Together Against Sizewell C

ISH10: COMMENTS ON MARINE ECOLOGY DOCUMENTS ISSUED AT DEADLINE 6

DR. P. A. HENDERSON

WEDNESDAY, 22 SEPTEMBER 2021

Figure 1 Simplified schematic of SZC cooling water system showing potential chlorination dosing points

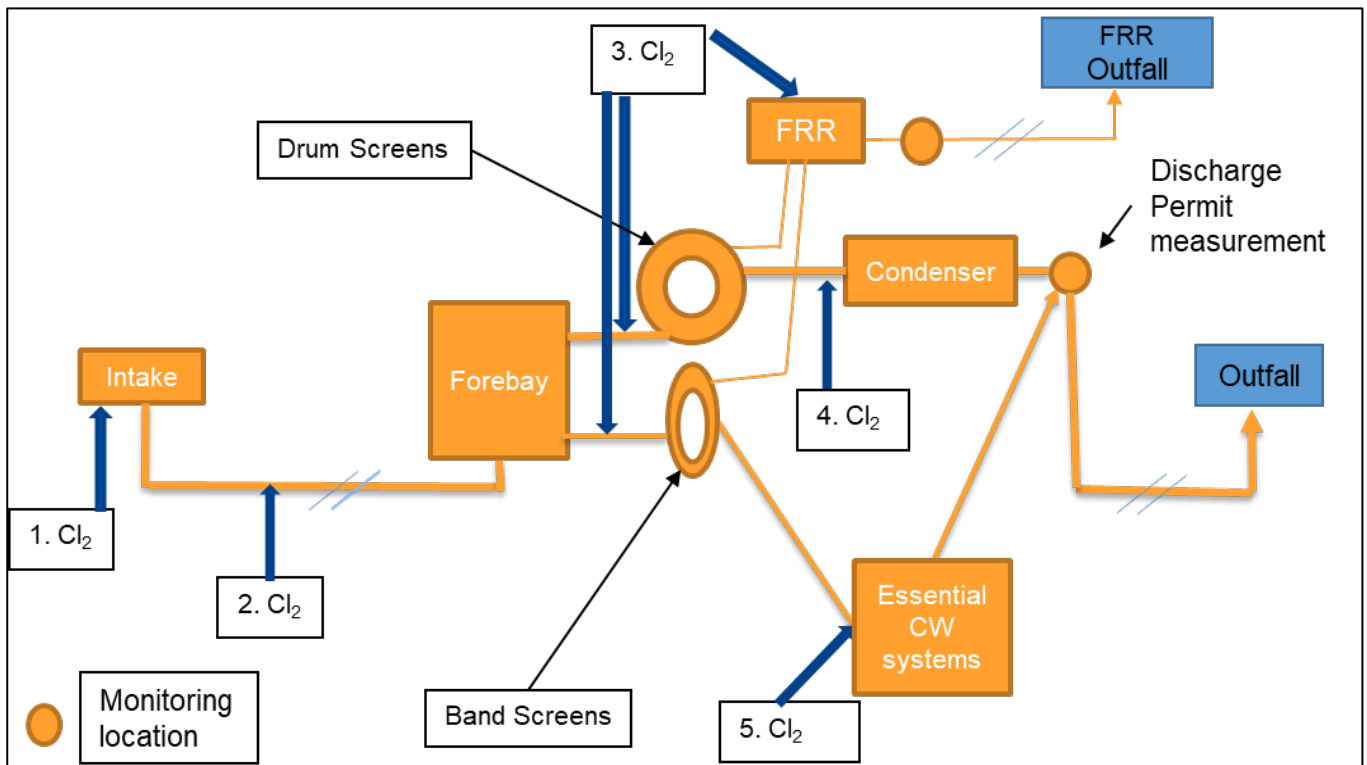
3. At earlier hearings and in written submissions I have raised the issue that the fish return system and the travelling screens will biofoul. This was previously recognised and it was, at one stage, proposed to chlorinate the screens and the FRR system. As stated on p27 para 8d, *“In order to protect the drum screens and FRR system, chlorinate (sic) the drum and band*

screen wells but only in the growing season when seawater temperatures exceed 10 °C.” An examination of cooling water intake temperatures at Sizewell B shows that the sea temperature (see Fig 1 below) exceeds 10 °C for a considerable proportion of each year and over most of the period when large numbers of fish are impinged. Further, if climate warming does occur as predicted then over the life of the proposed plant the proportion of the year with temperatures above 10 C will increase. The result is that the majority of fish returned to the sea via the FRR will have been exposed to chlorination should it be deployed. Chlorine is a broad-spectrum poison which is highly reactive and reacts with almost every constituent in natural waters, including made-made pollutants, yielding products having varying degrees of persistence and toxicity. It forms a wide range of organohalogenated compounds and chloramines depending upon the compounds present in the water. The total residual chlorine chronic toxicity threshold for aquatic life is 0.002 mg/l considerably below the proposed TRO of 0.2 mg/l¹. In Section 9 p 29, it is now stated that *“The successful conclusion of these studies means that the chlorination will not be applied before the SZC drum or band screens and that the subsequent addition of flushing water will not subsequently increase TRO levels within the FRR system (waste stream H).”* We are given no clear indication as to the nature of these studies which have reached this conclusion. However, the uncertainty is apparent because on p 29 it states that, *“In line with the strategy adopted at HPC, the chlorination dosing points in the screen wells before the drum and band screens will still be installed as a precaution but these would not be used unless there is a required change to the SZC chlorination strategy”*. It is my view that it is inevitable that these dosing points will be used; if they are installed it is essential that their impact on the efficiency of the FRR is assessed. Operational experience at Marchwood Power Station has recently shown that chlorination in front of the screens and the FRR system was essential to control biofouling. It is of great importance to assess the impact of these dosing points before the plant is constructed, as the EA would be placed in an impossible position if asked to license their use after the investment has been made.

### Appendix F HPC Pumping station CAD schematics

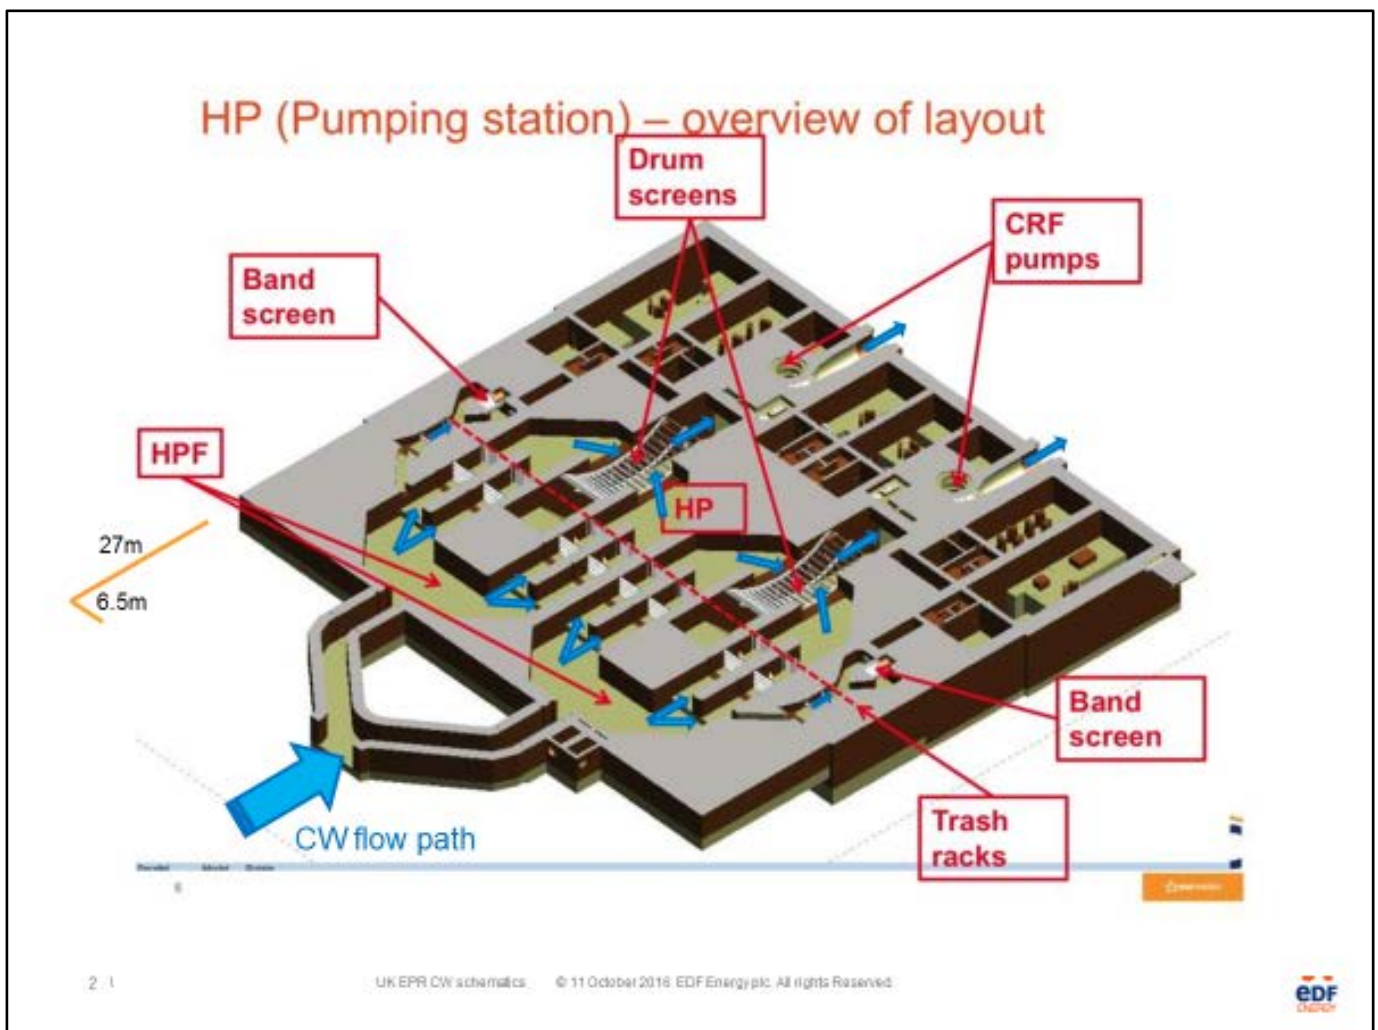
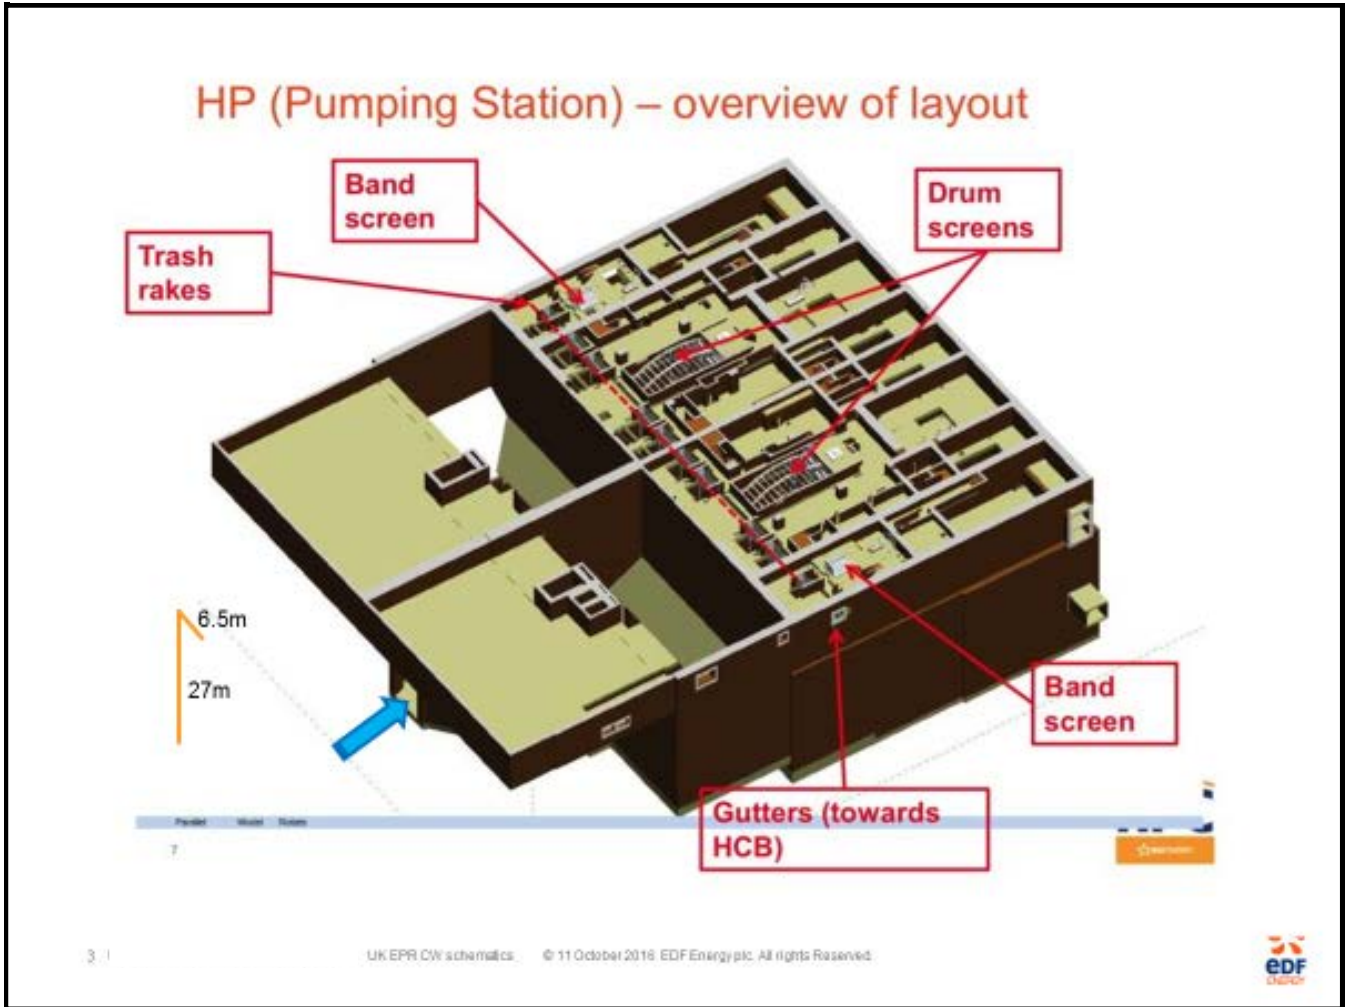
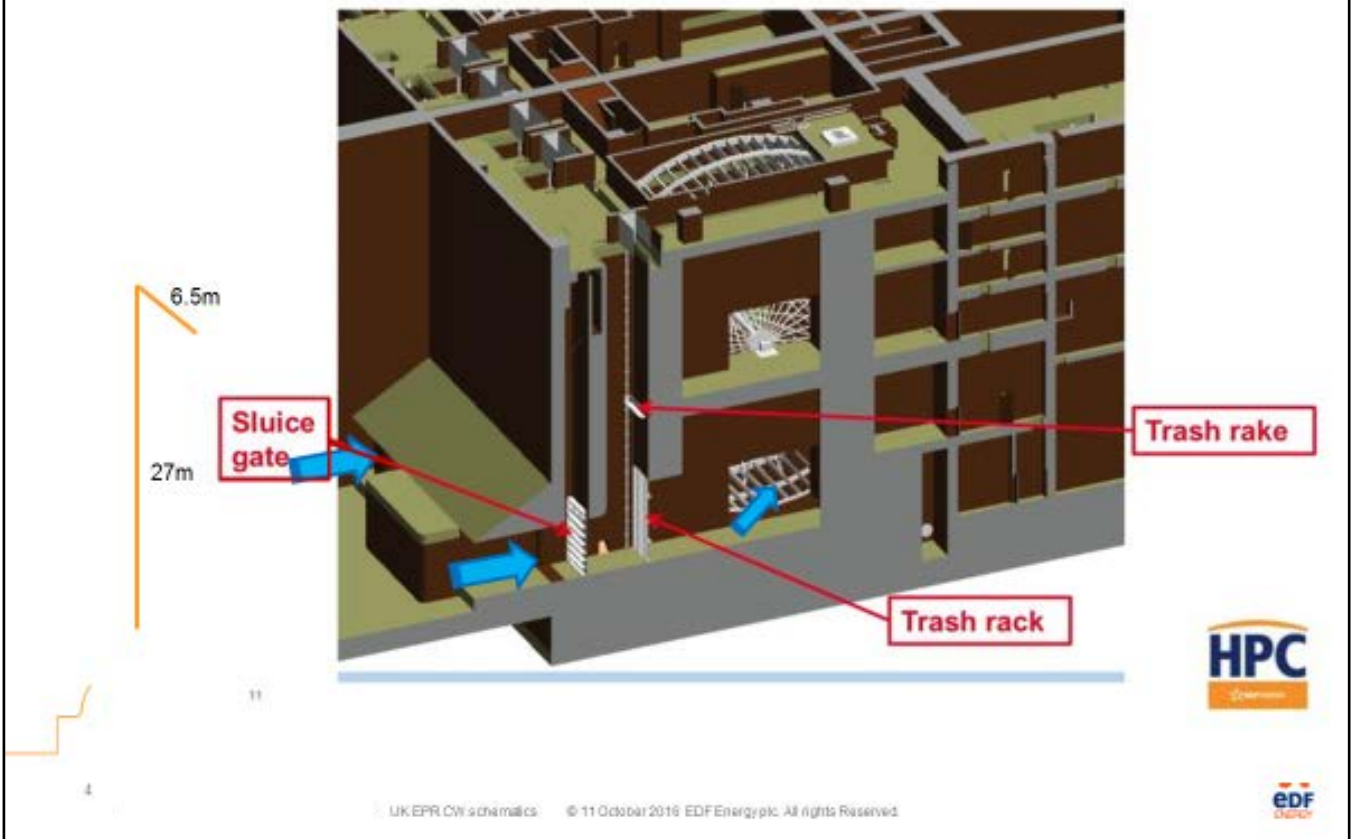
1. Hinkley C has been designed with an LVSE intake which is claimed to minimise fish ingress because of the low intake water velocity and how it is orientated with respect to the tidal flow. It has now been decided that a modified version of this design will be used at Sizewell C. The modified design is simplified with the removal of internal baffles which it is hoped will reduce vulnerability to fouling and the need to chlorinate the intakes. As stated on p 28 para 9.2, *“Without these internal baffles, EDF Energy’s engineers decided that these modified LVSE intakes would not require chlorination at the heads, thereby avoiding chlorinating the entire cooling water system.”* It was my understanding that the internal baffles in the intakes at Hinkley C were designed to orientate the flow of the water and reduce fish ingress. It is unclear why the same level of fish protection can be achieved at Sizewell C without the baffles. This needs to be explained.
